Application number: 2025/91557	
What is the application for?:	Erection of first floor side extension on supports
Address of the site or building:	12, St Andrew's Crescent, Oakenshaw, BD12 7EL
Postcode:	BD12 7EL

Objection - Application Number 2025/62/91557/E

In relation to the proposed extension 12 St Andrews Crescent and the impact / effect on the neighbouring property No. 14 St Andrews Crescent, Oakenshaw, Bradford, West Yorkshire, BD127EL.

Drawing No. 222/02

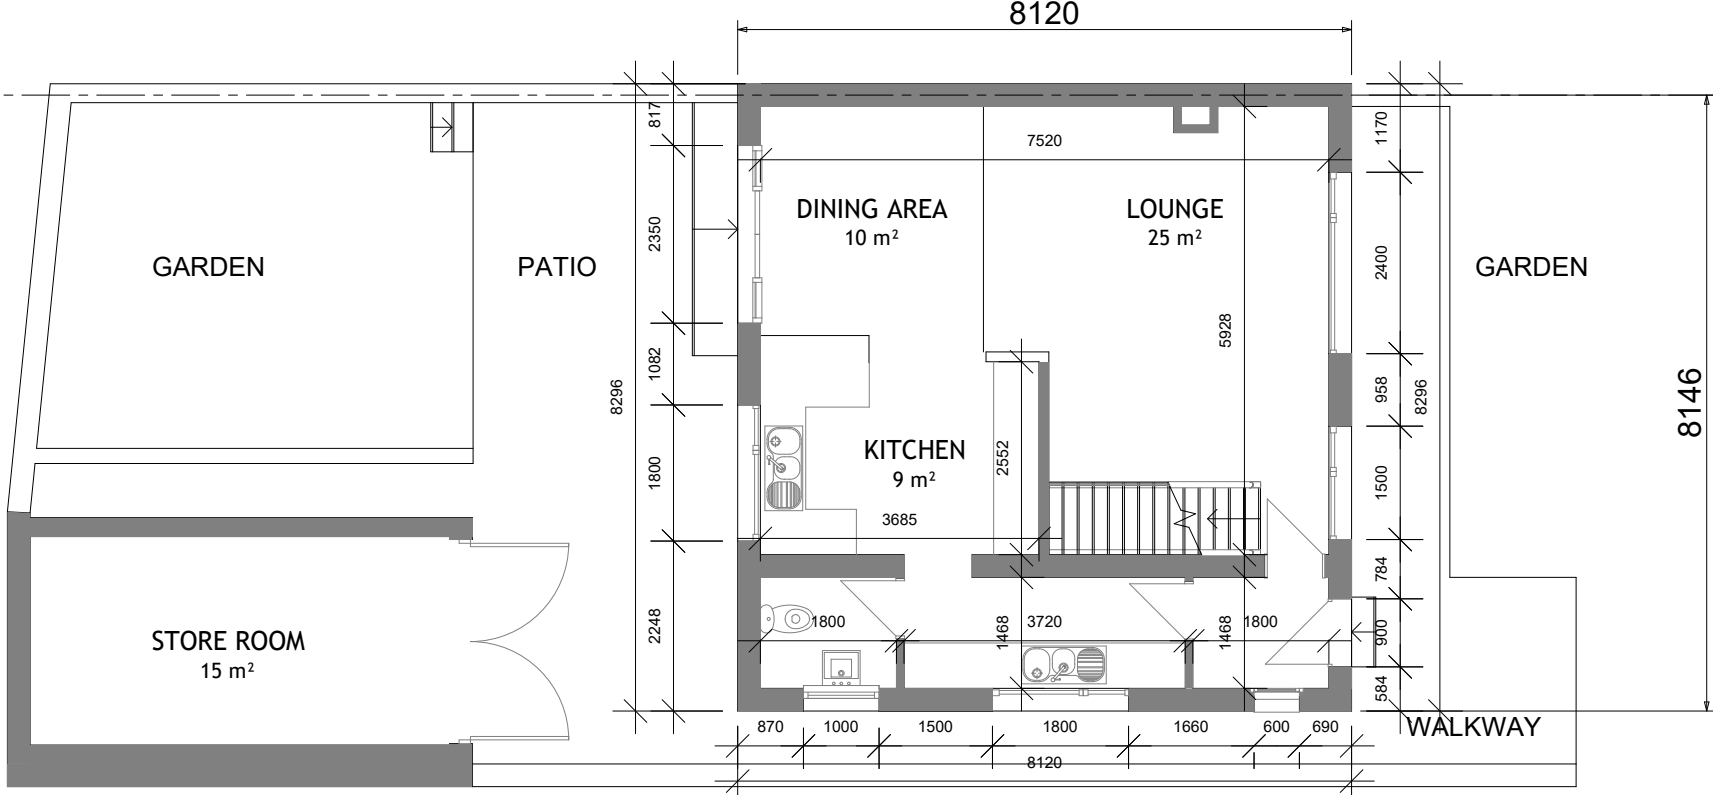
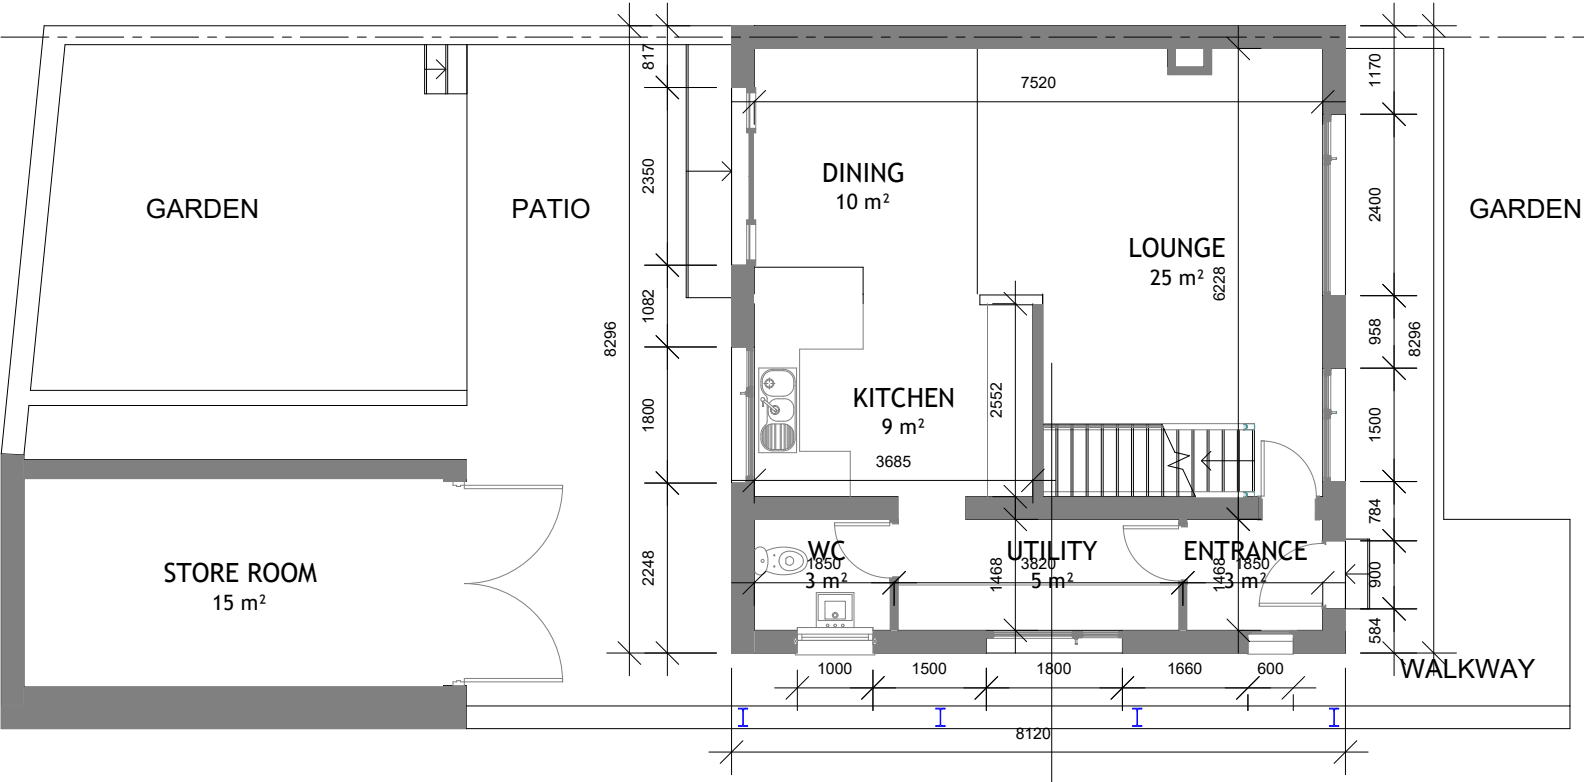
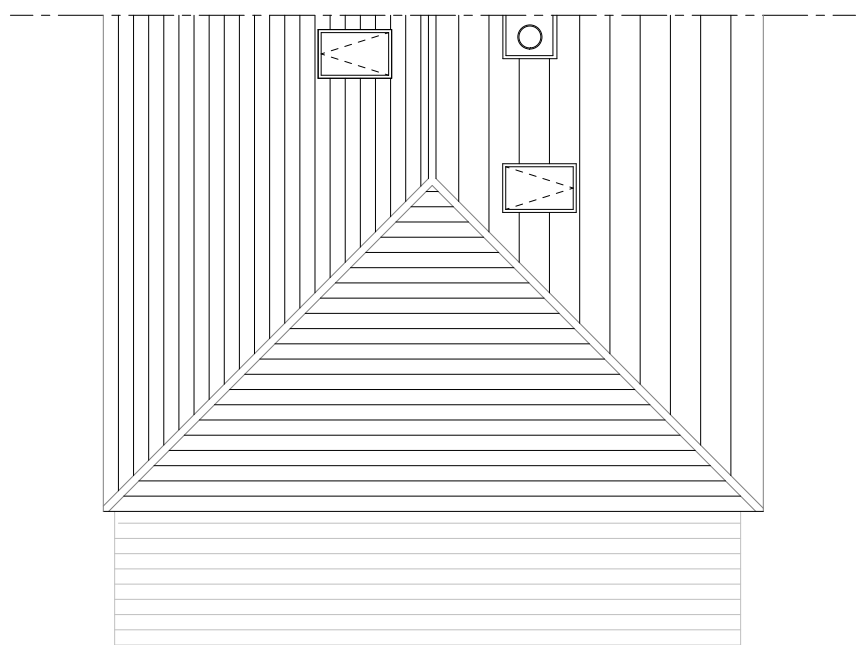
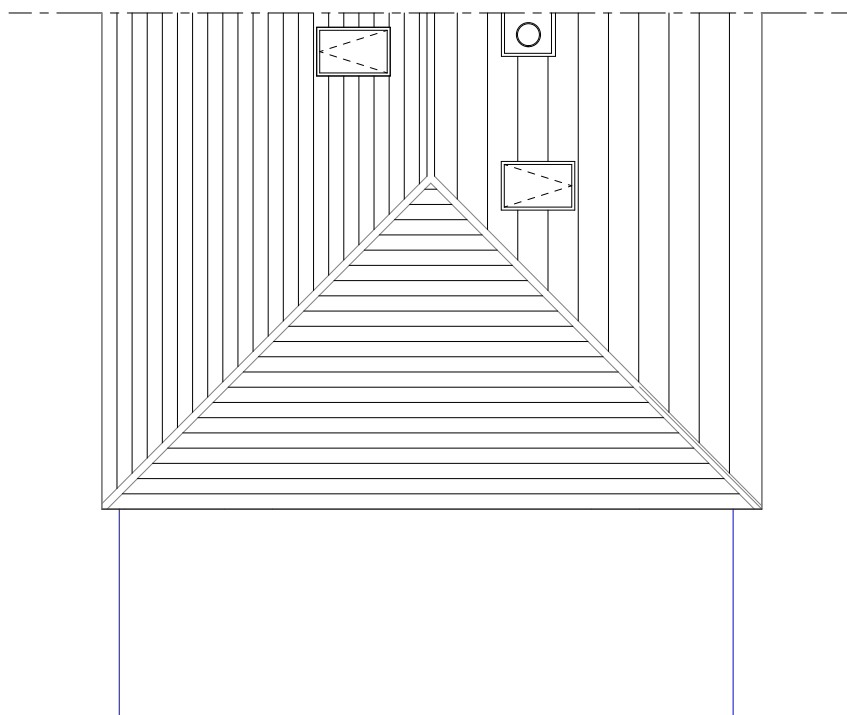
The new proposal potentially is nearer to the boundary than the initial proposal.

The proposed extension by virtue of the combination of the height, projection and proximity to the boundary will result in an overbearing structure which due to the orientation of the properties will cause overshadowing of the neighbouring dwelling No. 14. This also would cause a decrease in natural light. The proposed extension being even closer than the existing single storey extension.

The supports for the additional storey will be required to be positioned on the jointly owned boundary wall. No discussion has yet been held about how the applicants will access the construction without crossing onto the driveway of No. 14. We have yet to understand the load bearing implications of the structure being placed on the boundary to No.14 the neighbouring property.

In summary, the proposed extension will create a visual imbalance being a prominent feature in the street scene and will be harmful to the visual amenity of the area. Positioned on the boundary wall, by virtue of the design and overhang supporting pillars will be overbearing / overwhelming to our property.
